East Anglia ONE North and East Anglia TWO Offshore Windfarms

Updated Photomontages Clarification Note

Document Reference: ExA.AS-16.D3.V1

Drawing file: published-documents / EN010078-001386-6.2.29.13 EA2 ES Figure 29.13 Viewpoint 1 PRoW near Friston House (with National Grid AIS Substation).pdf

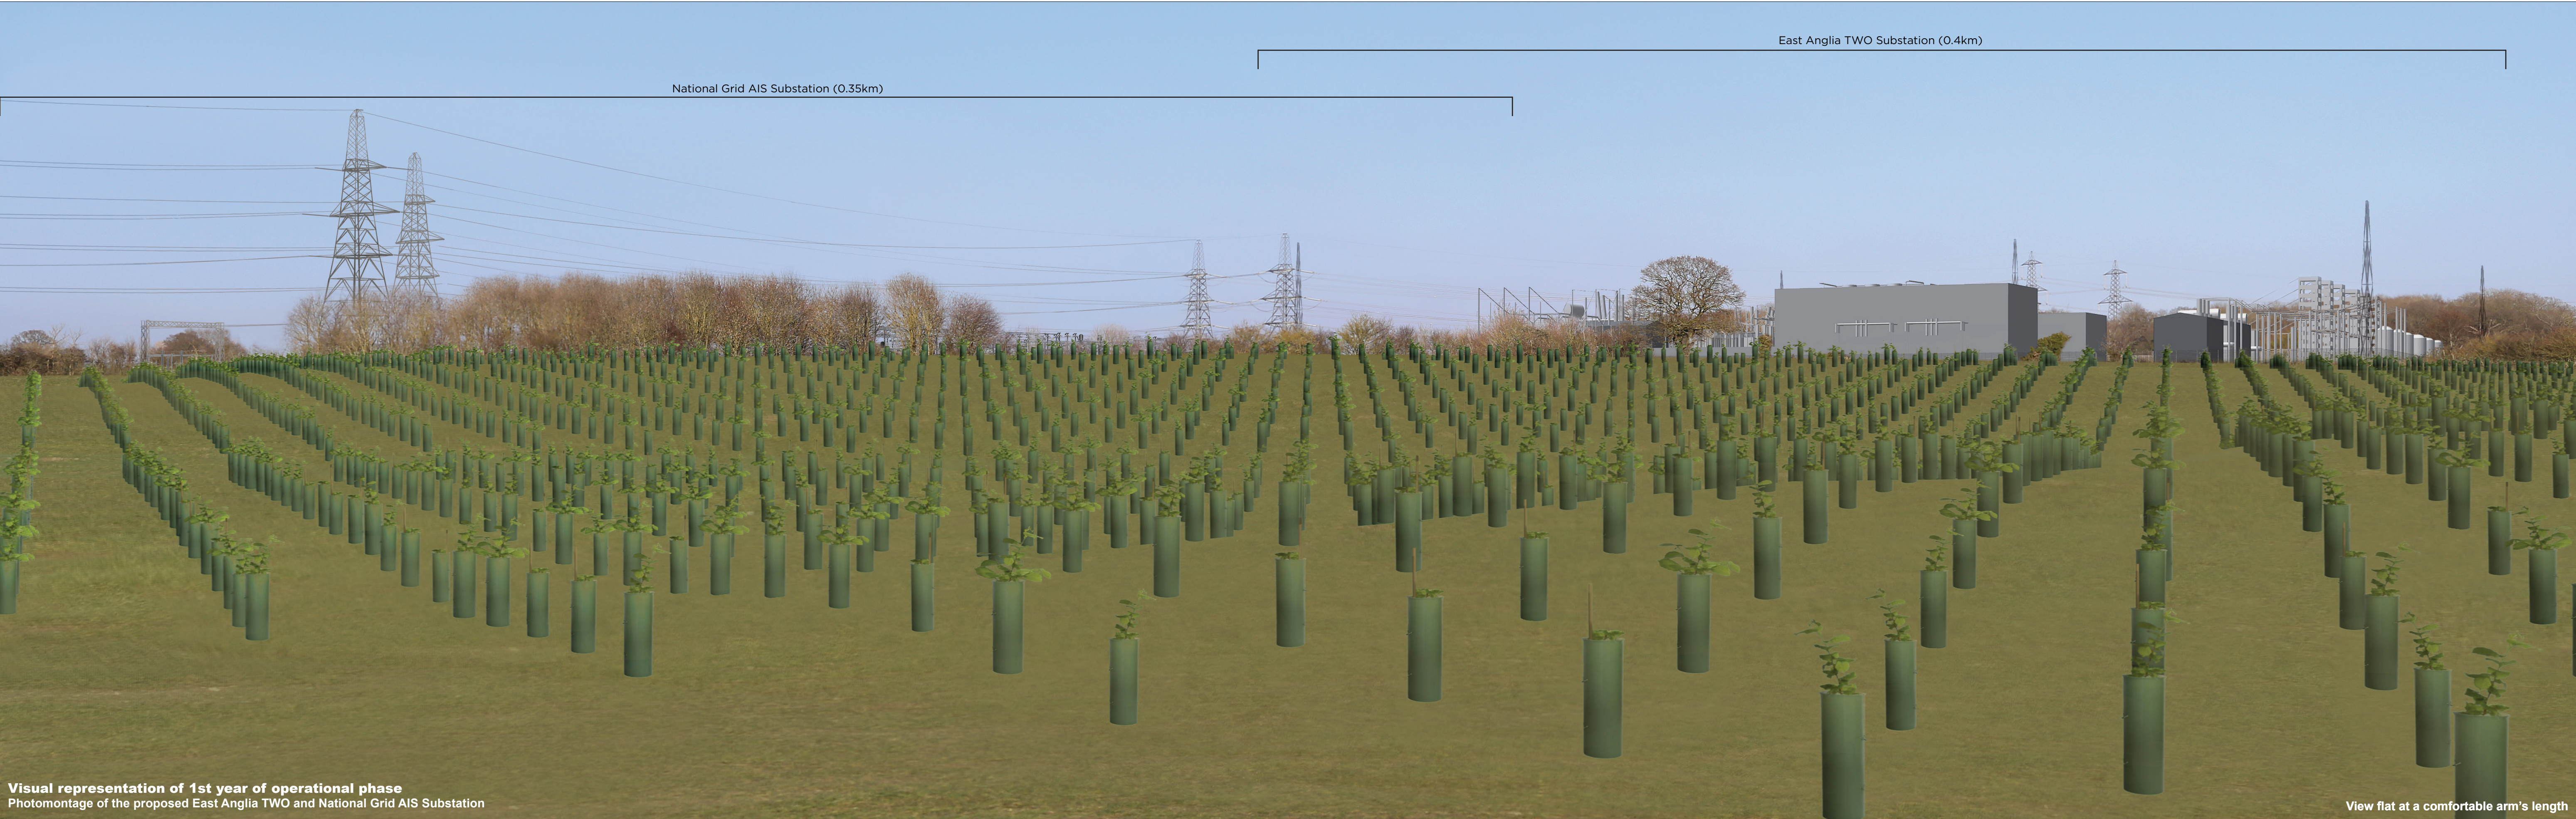
38. In its LIR (REP1-132), and raised at the SoCG meeting, the Councils have provided the following comments with reference to Viewpoint 1 (**Figure 29.13**) (APP-404):
- The image shows significant stem diameter typical of a tree that is 40 – 50 years old.
 - Significant lateral limb growth, again typical of a tree that is 40 – 50 years old.
 - Suggestion of secondary natural regeneration not usually found in recently planted woodland of only 15 years age.

49. In light of the comments provided from the Councils and the clarifications provided above, in order to resolve this matter and find common ground, the Applicants have produced an updated photomontage at Year 15 from Viewpoint 1 (**Figure 29.13-Update** in **Appendix 3**) (an extract of which is shown in **Plate 3.7**). Updates have been made to this visual representation to remove the two larger stemmed trees and reduce suggestions of leaf growth.
